From: Simon Davis
Sent: 06 February 2019 16:16
To: Planning.Responses
Subject: FW: Highfield Rd BR/215/18/PL
Attachments: 002-P-F.pdf; 003-P.pdf

From: Nick Hopper [REDACTED]
Sent: 06 February 2019 13:42
To: Simon Davis [REDACTED] Trish Paul [REDACTED] Trish Paul [REDACTED]
Subject: Re: Highfield Rd BR/215/18/PL

Attached revised plans showing Flats 1 and 3 are now in adherence of minimum space standard requirements as we have removed the wall from the studies to show an open plan 1 bedroom layout (bedroom to 11.5msq); You'll recall this was something we spoke about last week as a possible solution. Good to see you are now in agreement that all other units are in adherence to Minimum space standards as our original submission and as annotated;

Ground Floor Plan (Proposed) @ 1:100

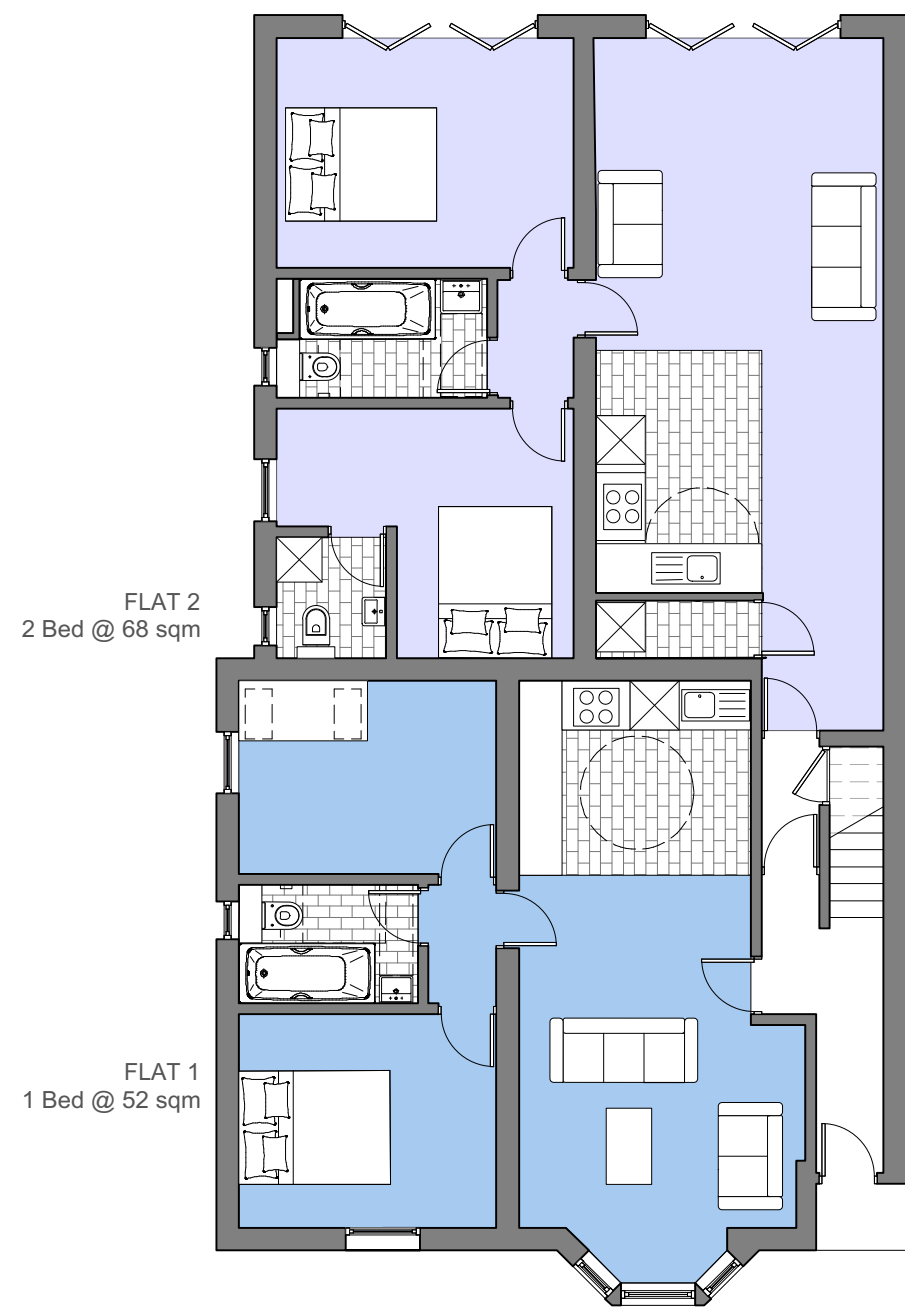
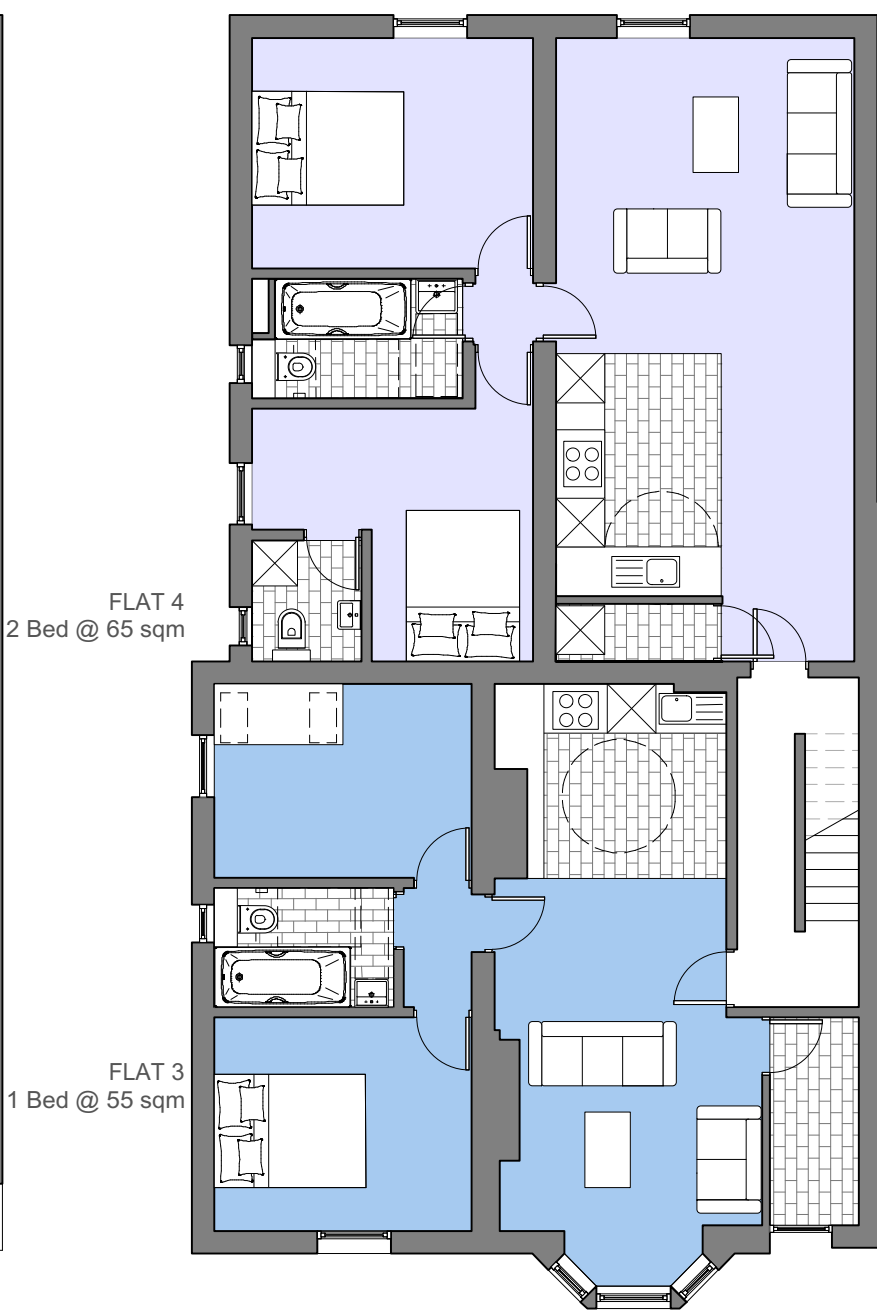
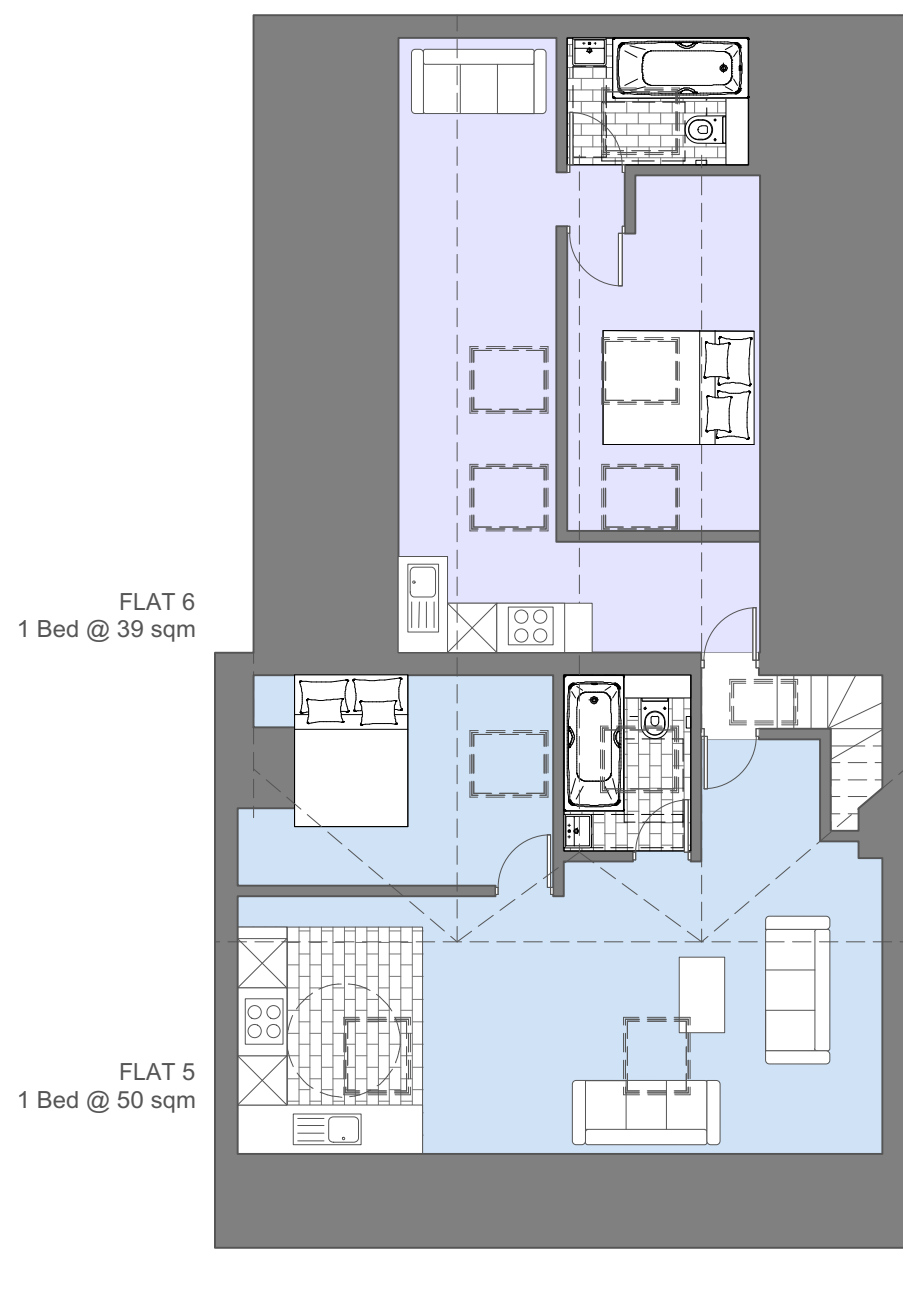
However, I have discussed this with our Group Head of Planning and although the national space standards do state that "Furnished layouts are not required to demonstrate compliance", we do not agree that this should be applied across the board and therefore, regardless of how the accommodation layout is shown (i.e. bed or desk), we should calculate the area requirements by size of room.

The standards say that a double is at least 11.5m² and a single at least 7.5m². I have therefore recalculated the requirements based on the size of the rooms and this means that now only 2 of the flats do not comply (see new table below). Clearly the two that do not comply are those that you suggest will be studies but we need to ensure that if the owner/occupier uses them as bedrooms then there is sufficient space elsewhere for their needs. We would be happy to defend this position on appeal.

Flat	No. Bedrooms	No. Persons	Requirement m ²	Proposed m ² (using your measurements)	Complies?
1	2	2	61	52	N
2	2	3	61	68	Y
3	2	2	61	55	N
4	2	2	61	65	Y
5	1	1	39	50	Y
6	1	1	39	39	Y

Many thanks for your time on Friday. As discussed please find attached revised plans indicating we have met minimum space standard requirements as annotated with the transference of single bedrooms to studies.
